Your ref:	233-237 Marylebone - small ca...	Please reply to:	Mr Anthony Perera
Our ref:	23/08476/FULL	Tel No:	07866034072
		Fee Queries:	0207 641 6500;
		Email:	planningreception@westminster.gov.uk;
N Griffin Inception Planning Limited Quatro House Frimley Road Camberley GU16 7ER		Incomplete Applications Town Planning & Building Control City of Westminster PO Box 732 Redhill, RH1 9FL	
		19 December 2023

Address: 233 - 237 Old Marylebone Road, London, NW1 5QT,

Proposal: Erection of canopy (6.1m x 4.6m) to the front of the building.

Proposed Elevations

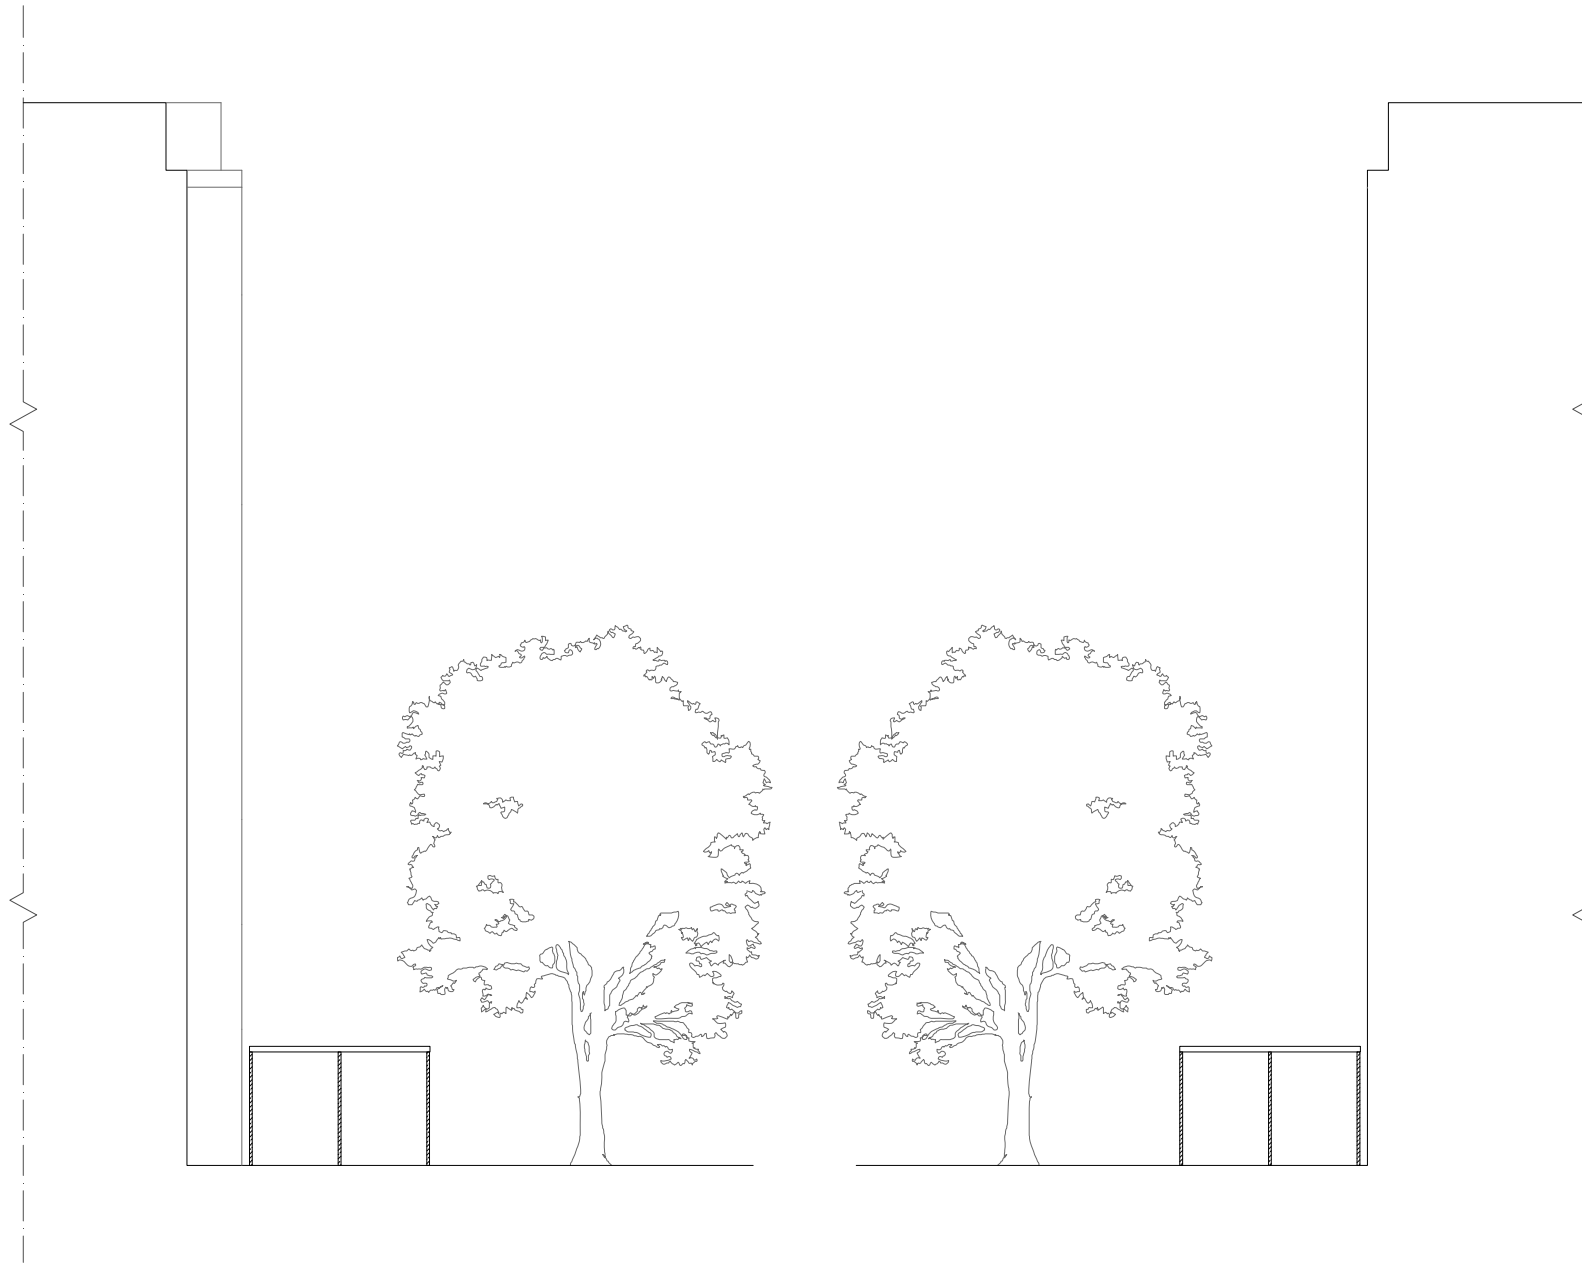
- Please provide specifications of the proposed canopy to show its colour, appearance and materials.

- Please confirm if this is a permanent structure.

- The structure is located under a trees canopy. We will require a arboricultural method statement
